From: [Harmon Rita T.](#)
To: ["Dave Aube"](#)
Subject: RE: Casa Feliz L19D073A-I
Date: Tuesday, May 03, 2016 9:43:31 AM

Senior Engineer, Hydrology Section
City of Albuquerque Planning Department
Development & Review Services Division
600 2nd St. NW, Suite 201
Albuquerque, NM 87102
t 505-924-3695

From: Dave Aube [mailto:daube@designgroupnm.com]
Sent: Monday, May 02, 2016 9:45 AM
To: Harmon Rita T.
Cc: Dave Aube
Subject: Casa Feliz L19D073A-I

CD-207

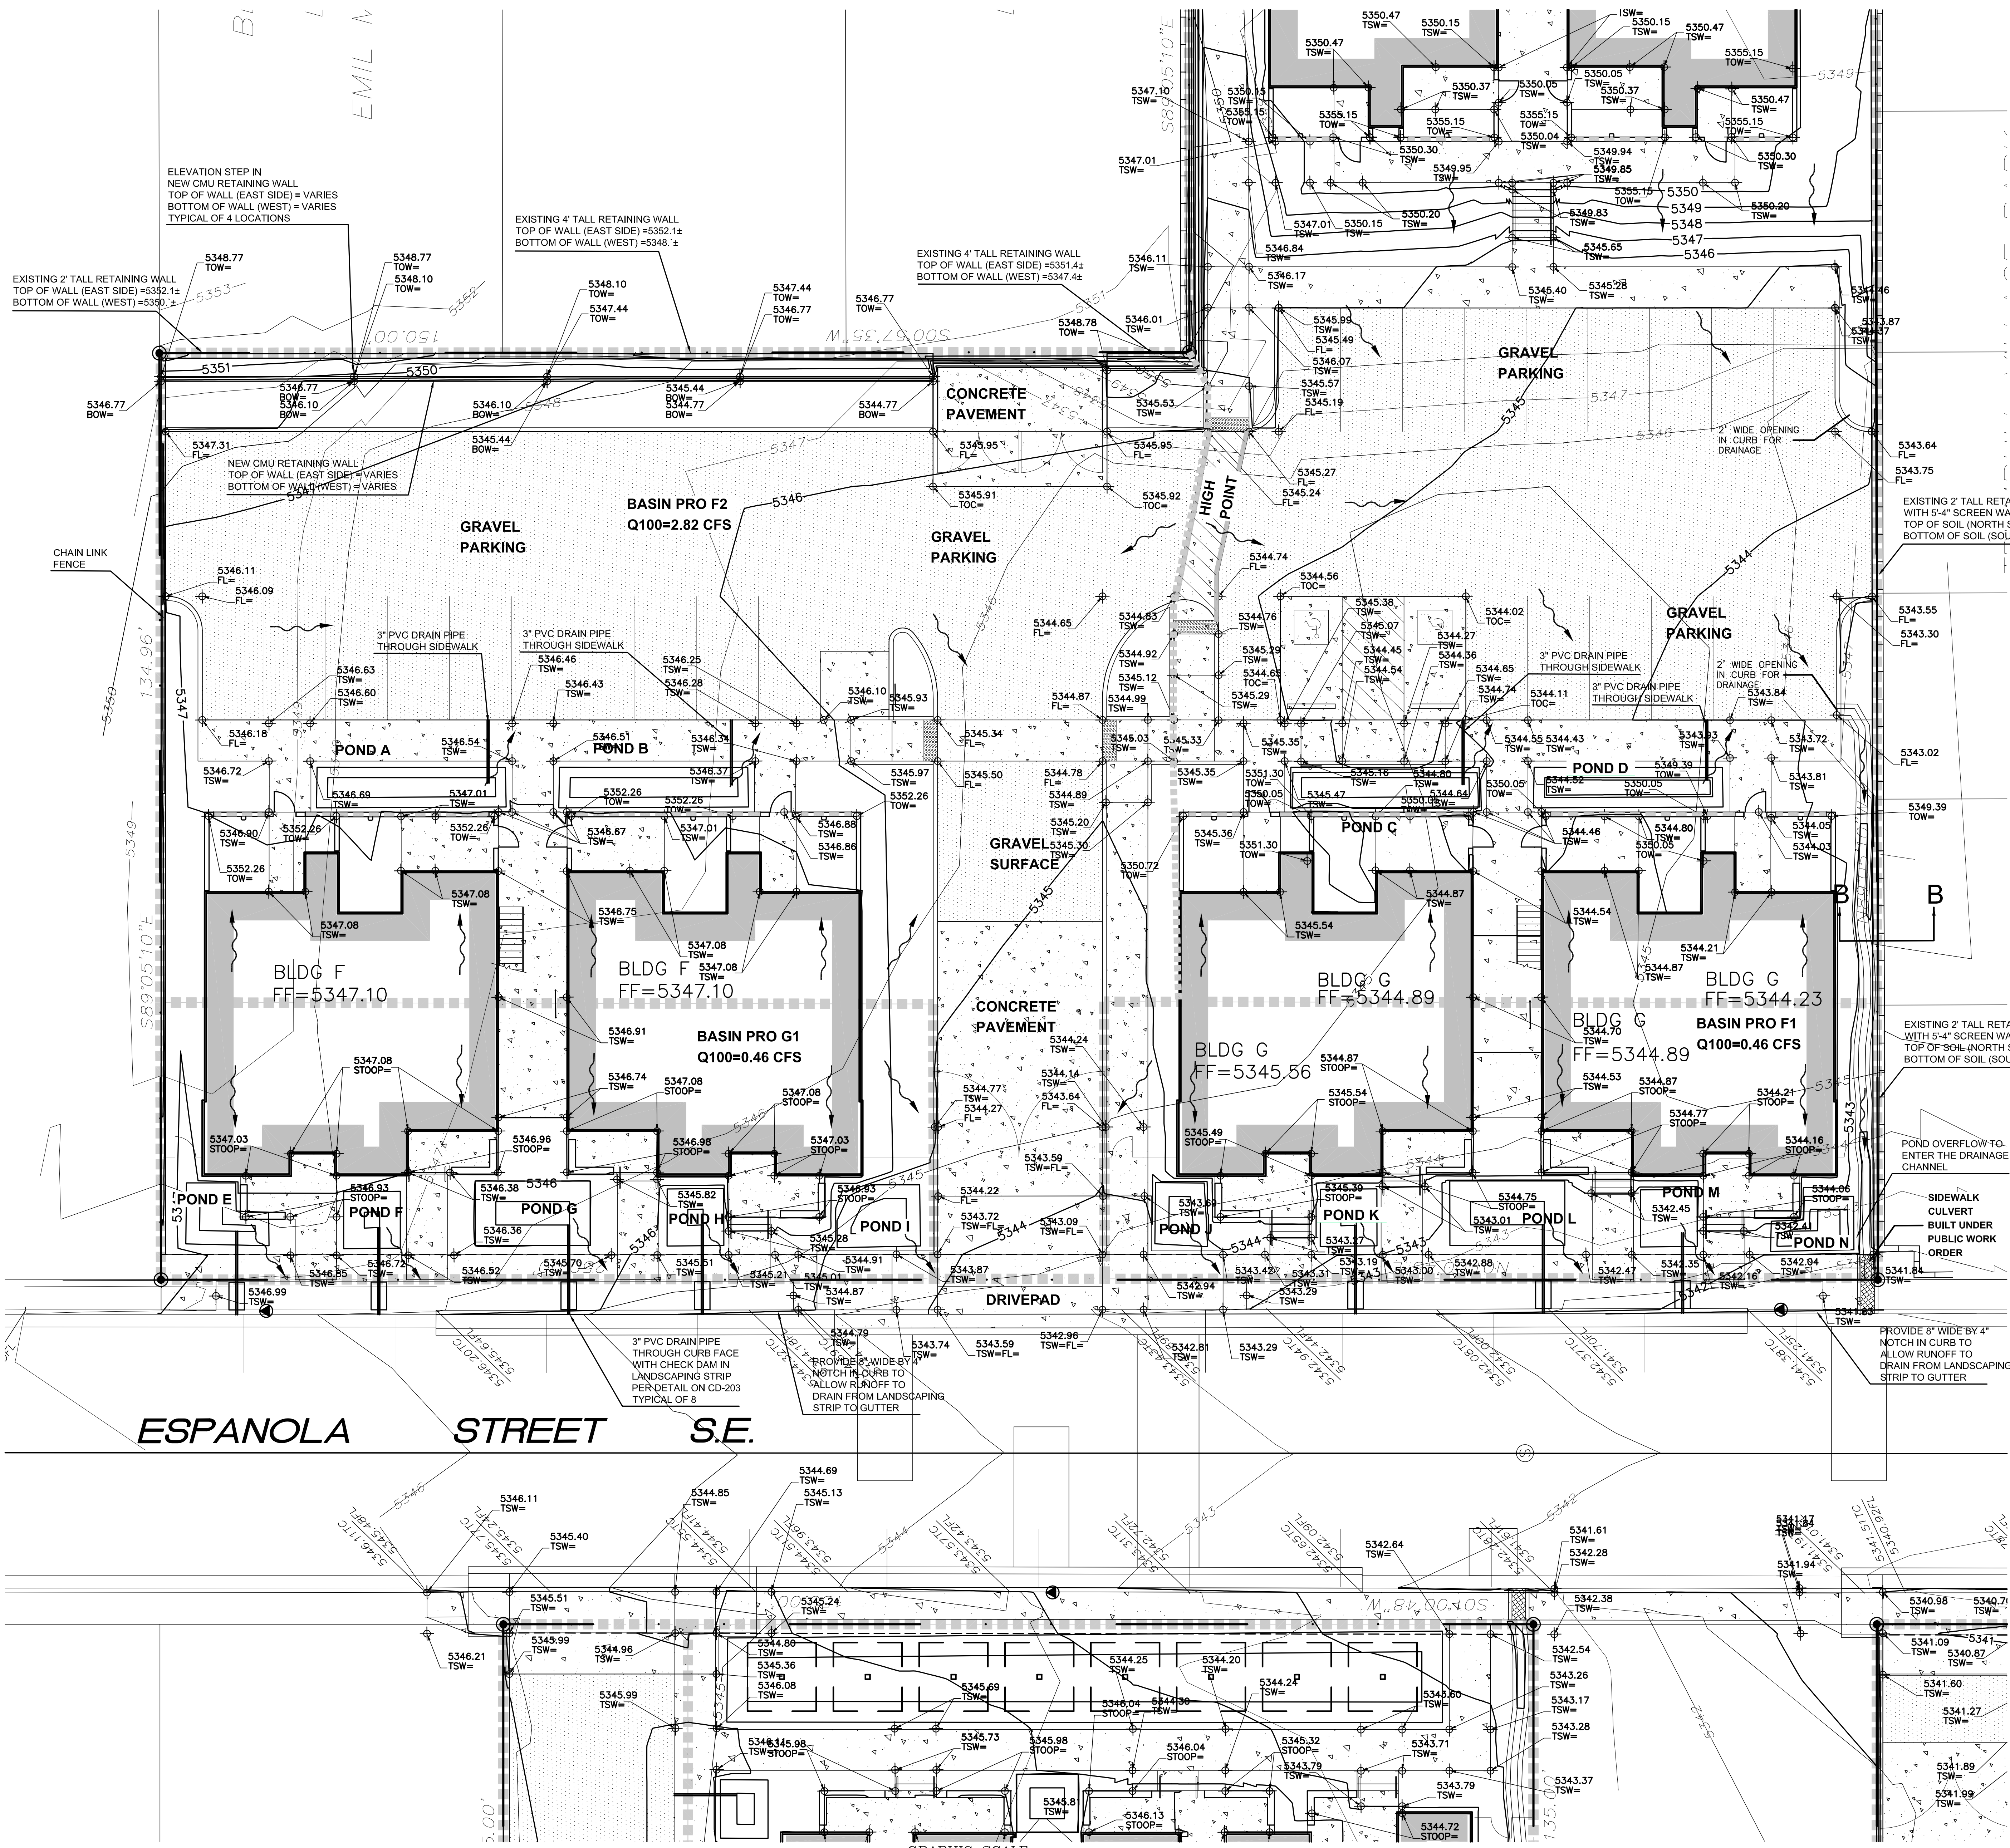
I took a more detailed look at the contributing basins and their peak flowrates. It appears that the max that we would see out of these basins is 0.15 cfs that could overtop the sidewalk during the 100year storm event. The average is 0.11 cfs that overflows the first flush ponding areas.

Based on these small volumes, I think that installing a 4" discharge pipe through the curb, may be causing more harm than good. The other issue is to get the grades to work the invert of the pipe discharges from the first flush ponds would need to be at the base of the pond and would reduce or eliminate any on-site storage of the first flush volumes.

At this time I would like authorization to remove the 4" discharge pipes between the shallow ponds and the public curb face.

I agree that the 4" PVC pipes should be eliminated, and that the first flush ponds should overflow across the sidewalks in a sheet flow manner. Rather than resubmit a revised grading plan, with a new approval, this email serves as Hydrology's acceptance of this change and will be added to the drainage file to document the change. Please be sure to note the change on the As-built drawing when requesting C.O.
